Issue Specific Hearing 2

Supplementary Agenda Additional Questions – ERYC Response

Figure 2: Bat calls recorded during October static monitoring at locations T4, T5 and T8 within the Dogger Bank South Offshore Wind Farms Bat

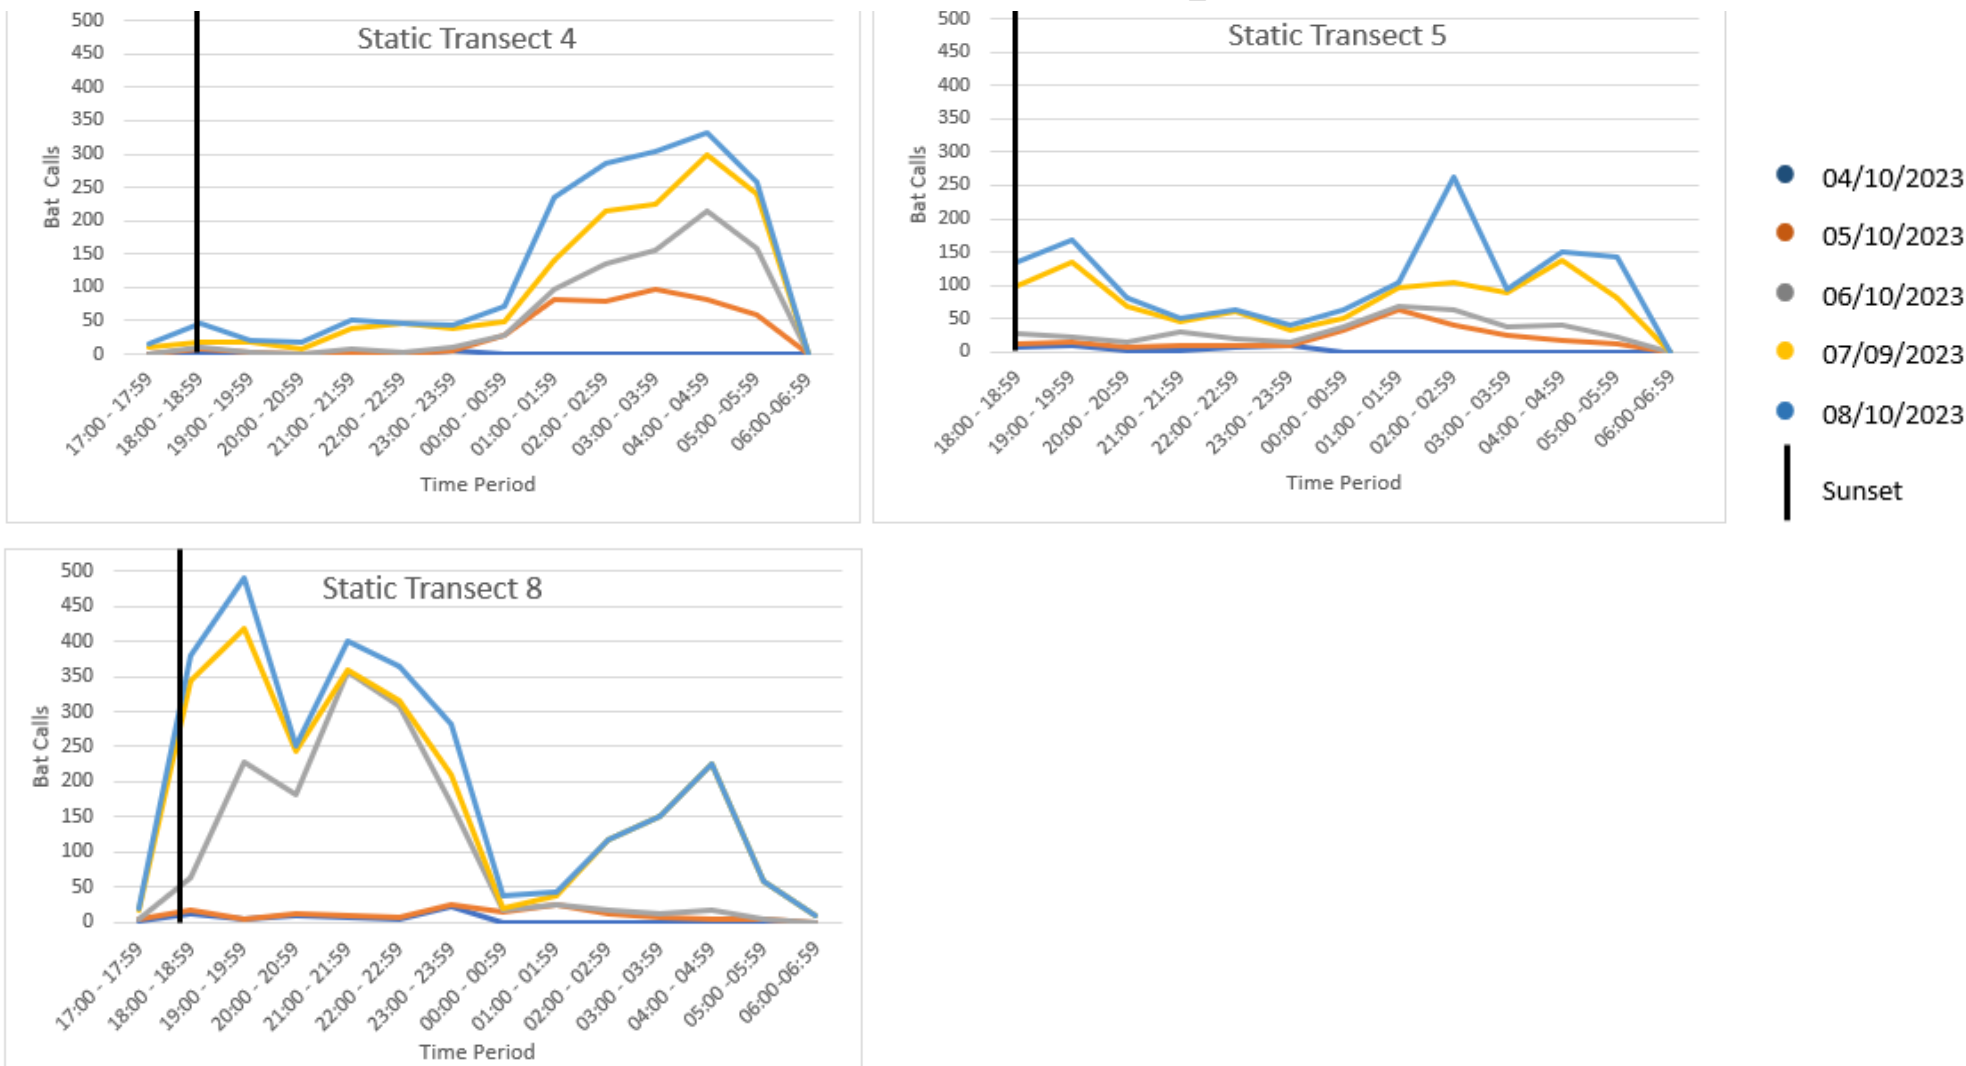
ISH2.12.4	Your Local Impact Report would not appear to make reference to the appropriateness or information in relation to commuting and foraging bats. Please could you confirm your views on the assessment of commuting and foraging bats? Do you consider additional mitigation	An oversight led to the response on commuting and foraging bats being omitted from the ERYC Local Impact Report [PDC-007] and is provided below. Transect and static monitoring surveys have been undertaken, equipment failure is noted and it is agreed that this does not pose a significant constraint to interpretation of the data or understanding the use of the onshore cable corridor by bats. Common and widespread species typical of the region were recorded. Of note is the increased, activity recorded in October at locations T4, T5 and

<p>measures should be considered and, if so, what should they be?</p>	<p>T8. Section 4 of the Bat Surveys: Transects and Static Monitoring, Issue 7(Peak Ecology, 2024) provides guidance on project design and methodology to avoid and mitigate impacts on bats and many of these are secured in para 99 – 106 of APP-235 which is welcomed, however, there is no further narrative on the potential swarming site where APP-146 recommends “Further survey would be required to determine the cause of the increased activity in October. It is recommended that works in these areas do not take place overnight and artificial light is minimised during the autumn months (September to November) to avoid disturbance or disruption of flight lines and foraging features.” Para 178 of APP-235 detailed restrictions on night lighting that would benefit bats and this could be extended to November as recommended in APP-146.</p> <p>This has subsequently been discussed at the Expert Topic Group and the Local Authority are satisfied that this embedded mitigation running to 31st October is a sufficiently precautionary approach to the potential construction impacts on foraging and commuting bats. Replacement of hedgerows as soon as possible following construction works is also welcomed.</p>
